Recommendation Report for Planning Permission

REF NO: BR/174/25/PL

LOCATION: 17 High Street
Bognor Regis
PO21 1RJ

PROPOSAL: Conversion of vacant Class E building and erection of a first-floor extension to create 7 No. dwellings and a reduced Class E unit (resubmission following BR/72/25/PL). This application may affect the setting of a listed building and is in CIL Zone 4 (Zero Rated) as other development.

Proposed Ground Floor - 1:200

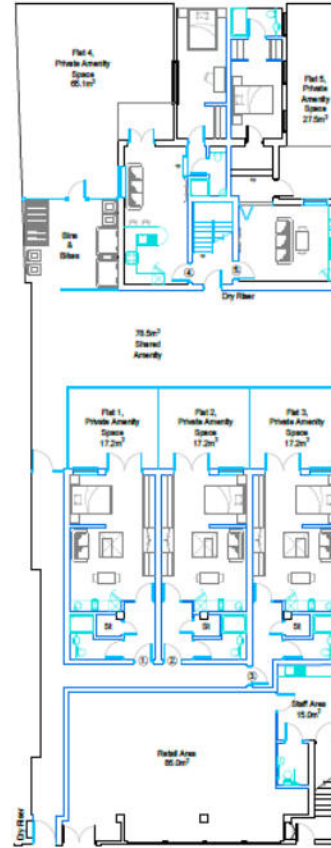
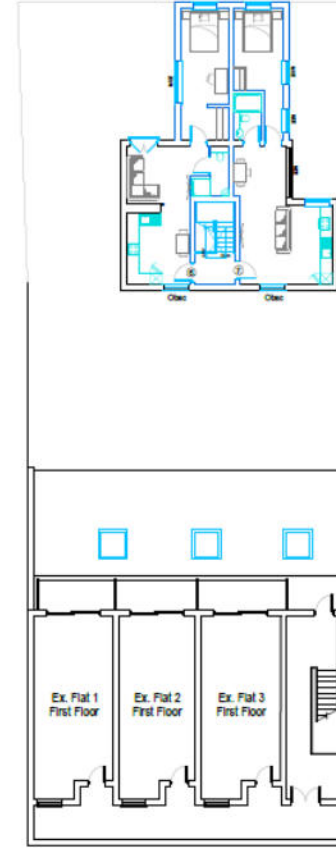
In terms of overbearing and overshadowing, the only element of consideration is the first floor extension to the rear portion of the site to facilitate the creation of the two first floor flats. This will result in the creation of further first floor development measuring 6m high (to align with the existing first floor) which will span up to the southern boundary; abutting Belmont Lodge. There will be no adverse harm posed to the neighbouring properties to the east and west. The proposal will result in some overshadowing of Belmont Lodge; however as this will abut existing built form, and not overshadow any habitable areas or amenity areas, this impact will be acceptable and will not adversely harm residential amenity.

In respect of overlooking, only the first floor side openings pose any risk of harm to residential amenity and privacy. This is primarily the window openings on the west elevation, which will face onto the neighbouring property to its west. These windows serve the proposed dining area and bedroom for Flat 7. Those in the dining room will be high level, and as such pose no demonstrable harm of overlooking. The windows to the bedroom would only have minor visibility of neighbouring windows to the west, and as such would not pose enough level of harm to be considered detrimental to residential privacy and amenity.

The previous application suggested the occupiers of the ground floor units can reach safe refuge on the stairwells to the first floor flats and this position remains the same. No further information has been submitted to address this or identify how evacuation would take place without being reliant on stairwells to provide escape access.

The flood risk to the site is a significant issue, as the proposal would result in the creation of 5 No. ground floor residential units. As such, whilst the site at present incorporates flats at first floor, the change to the ground floor retail unit to residential use will result in the vulnerability of the whole site increasing from a 'less vulnerable use' to 'more vulnerable use', as set out by Annex 3 of the NPPF.
